2280.08-DRAWING REVISION SCHEDULE

MOD18 - A0003 - SHADOW DIAGRAM 21 DECEMBER

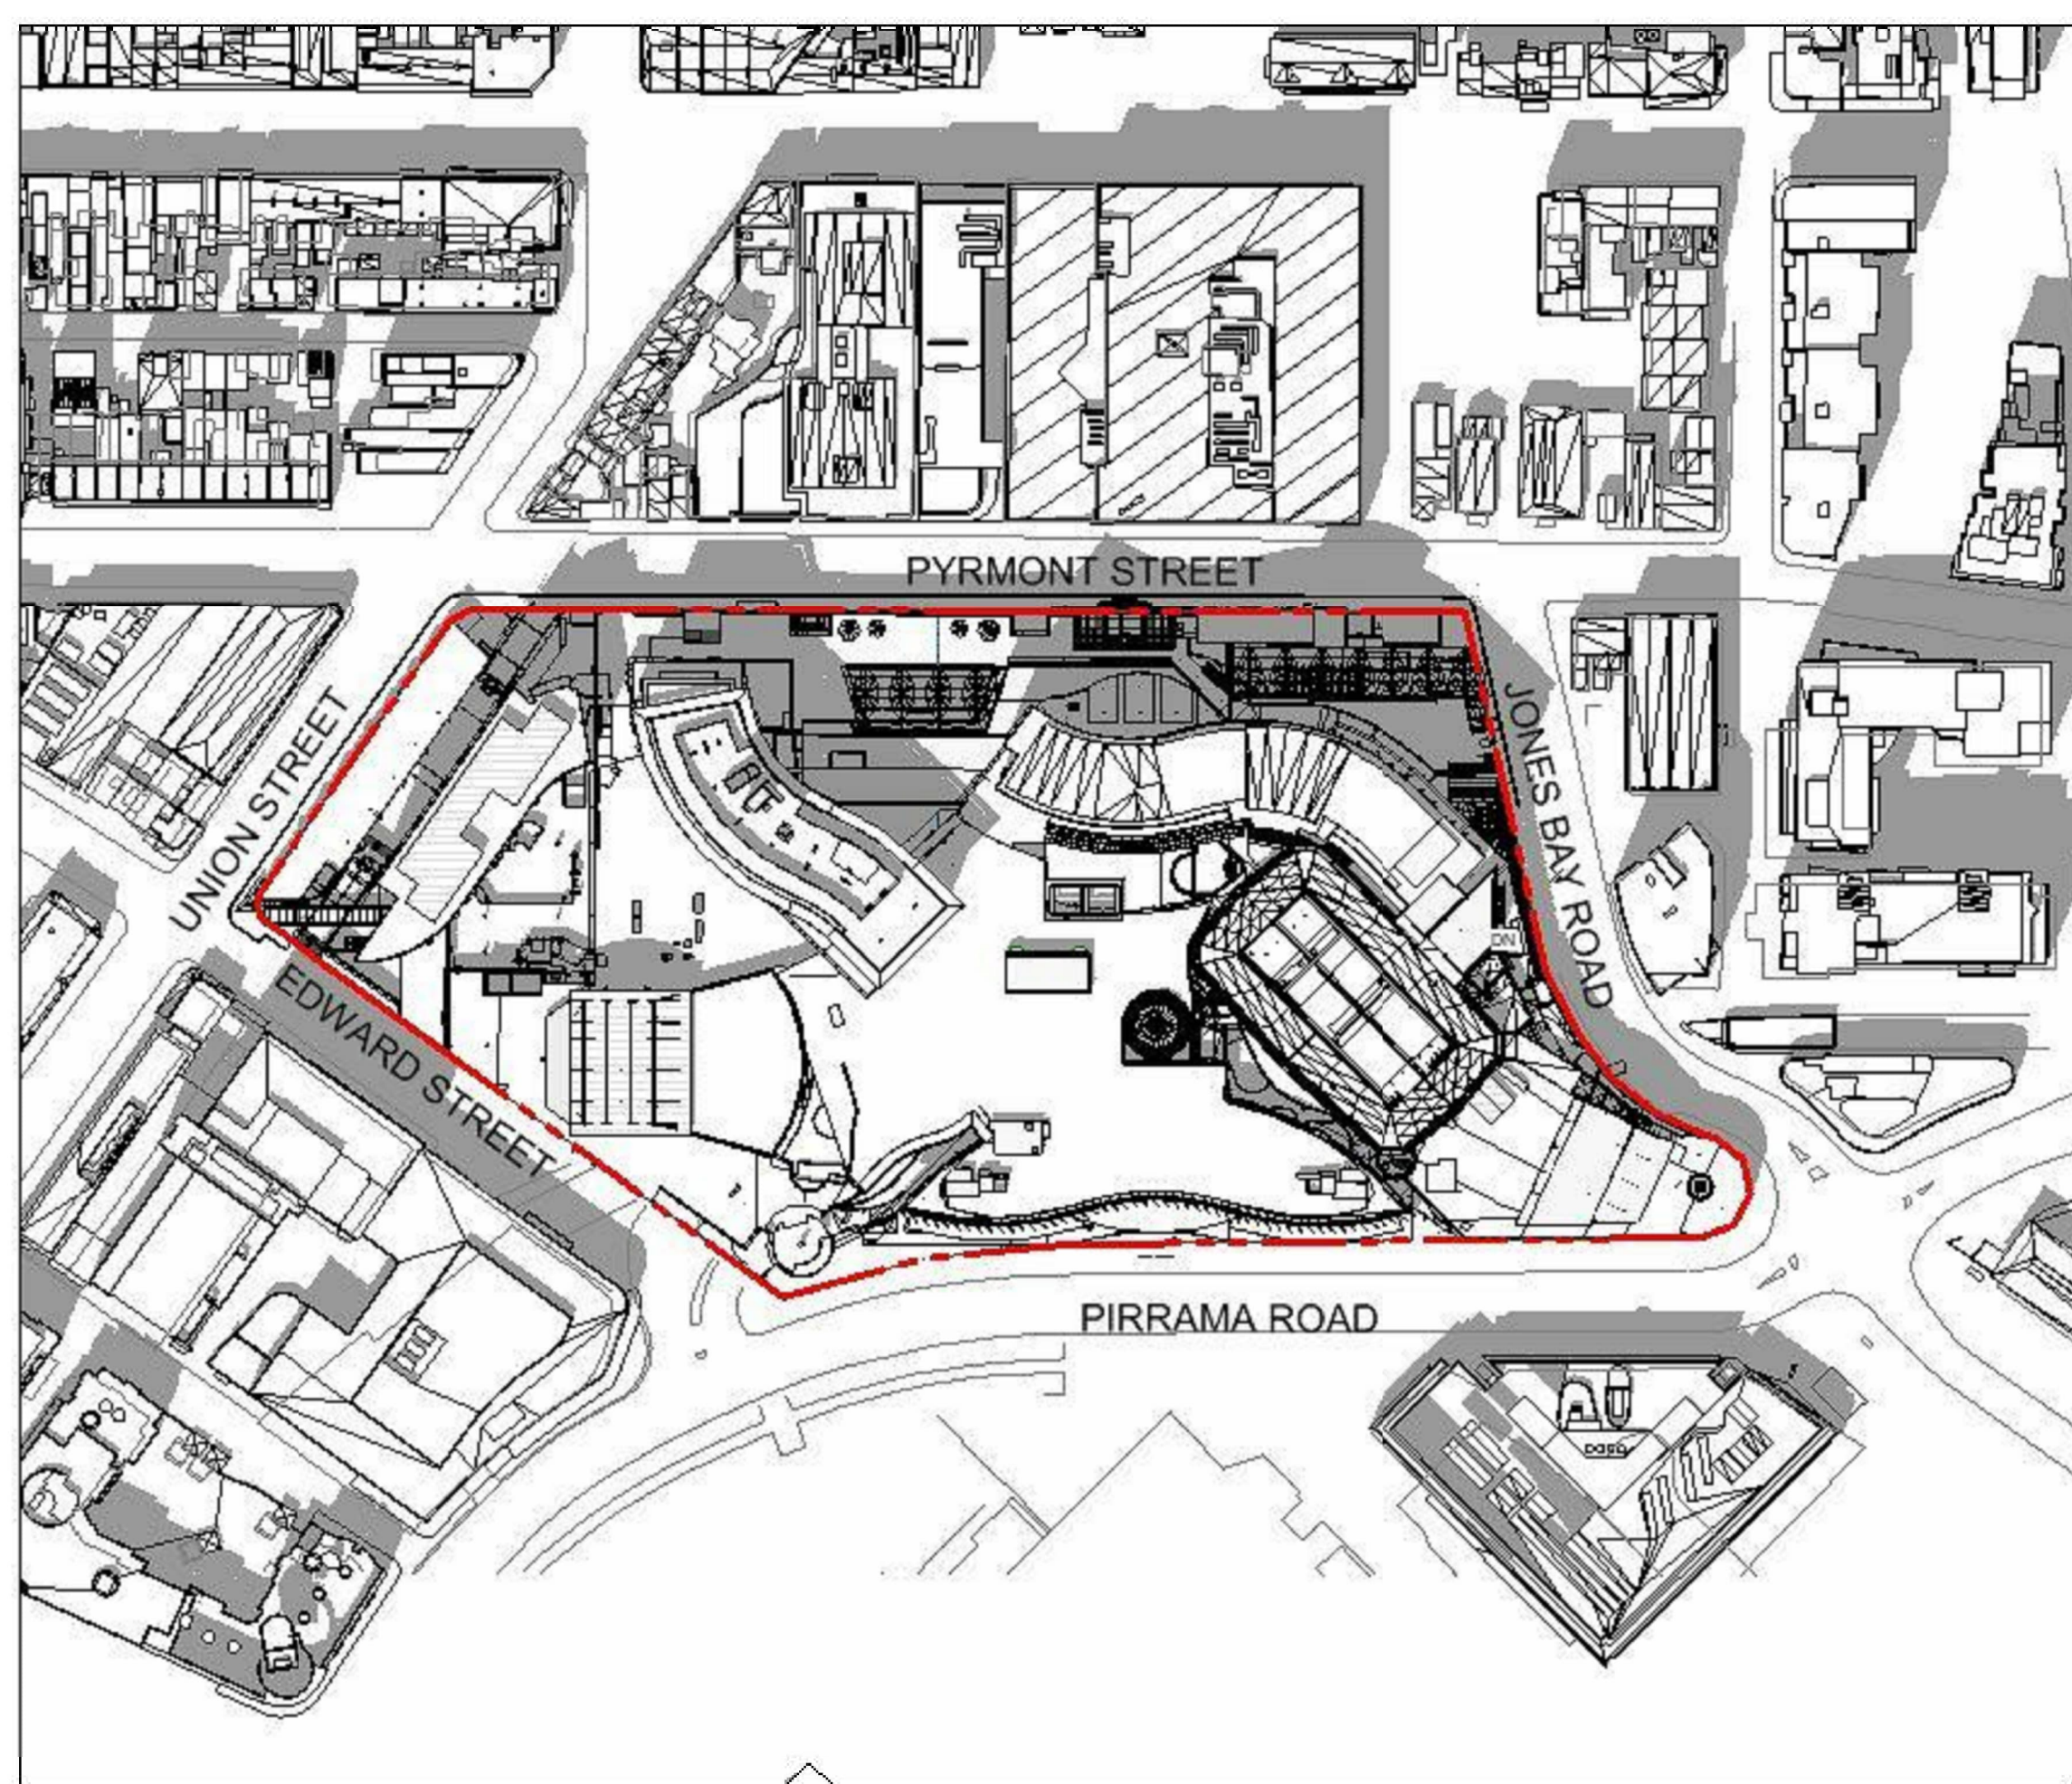
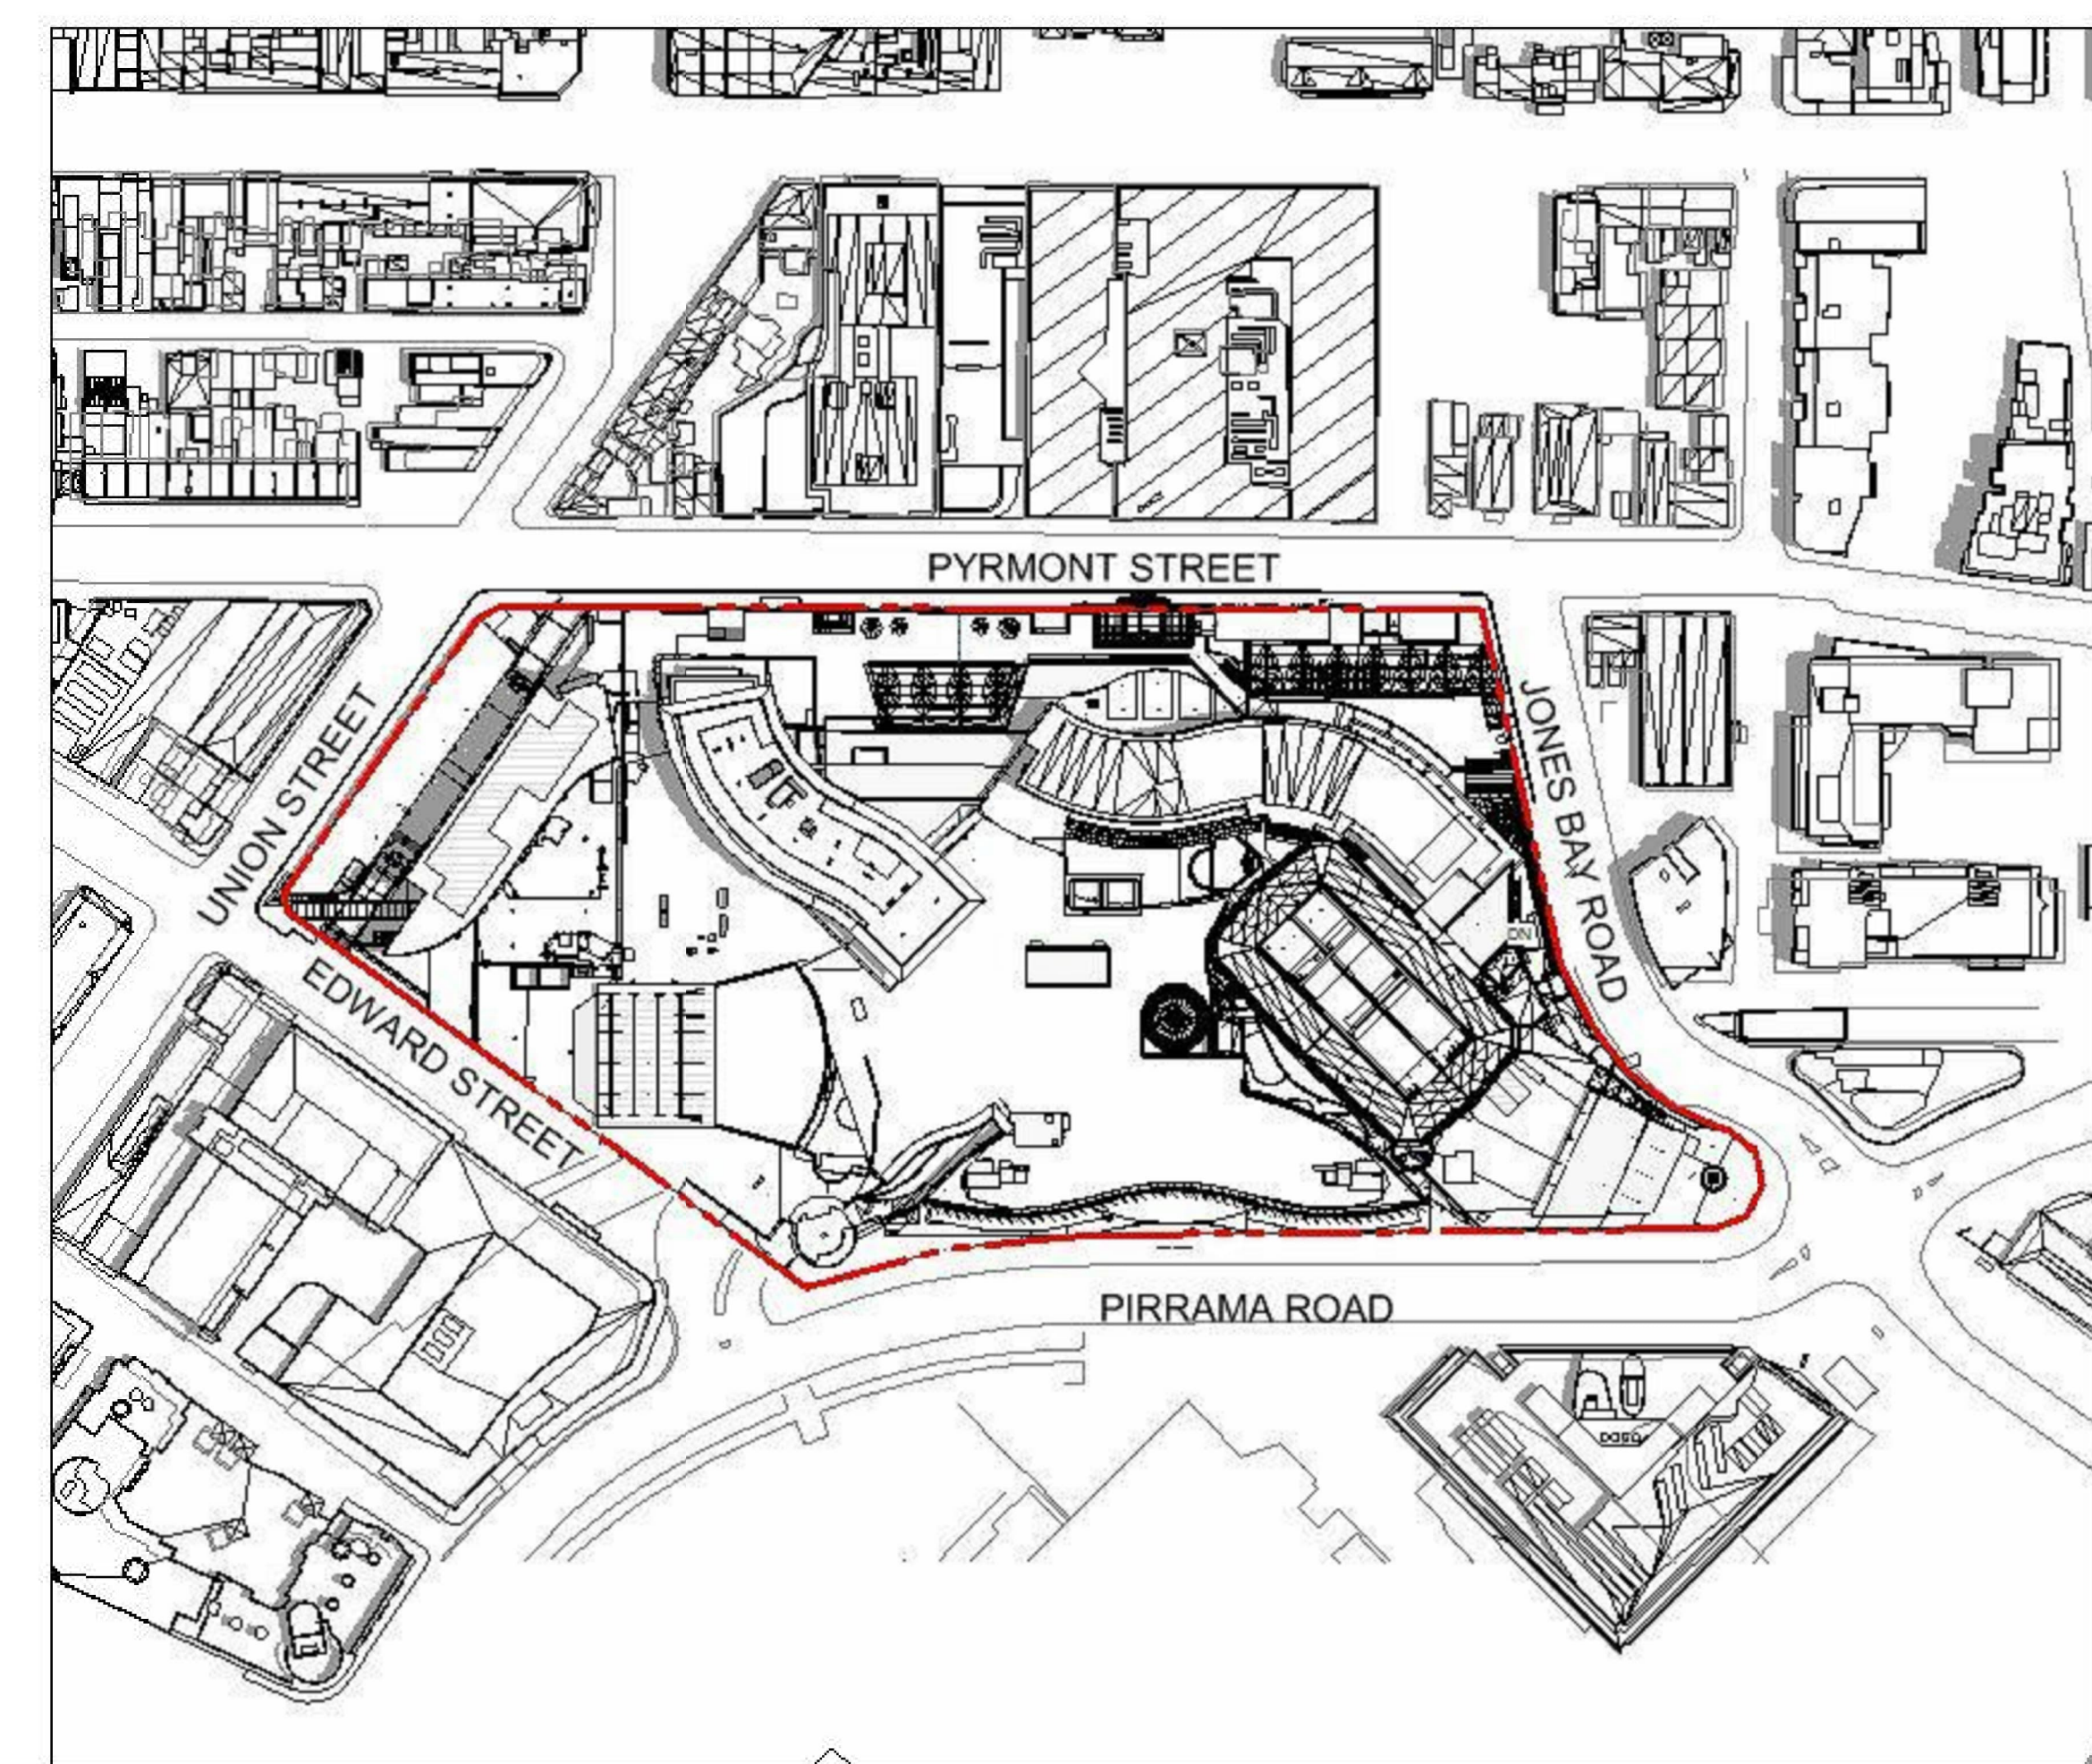
1. Footprint of fly tower reduced to suit comments from DPE and City of Sydney.
2. 4 level extension over existing dressing rooms reduced to 3 levels over existing dressing rooms. Aluminium clad screen extending from 4 level extension and on front of existing plant room omitted.
3. Double height plant room extension omitted from scope.
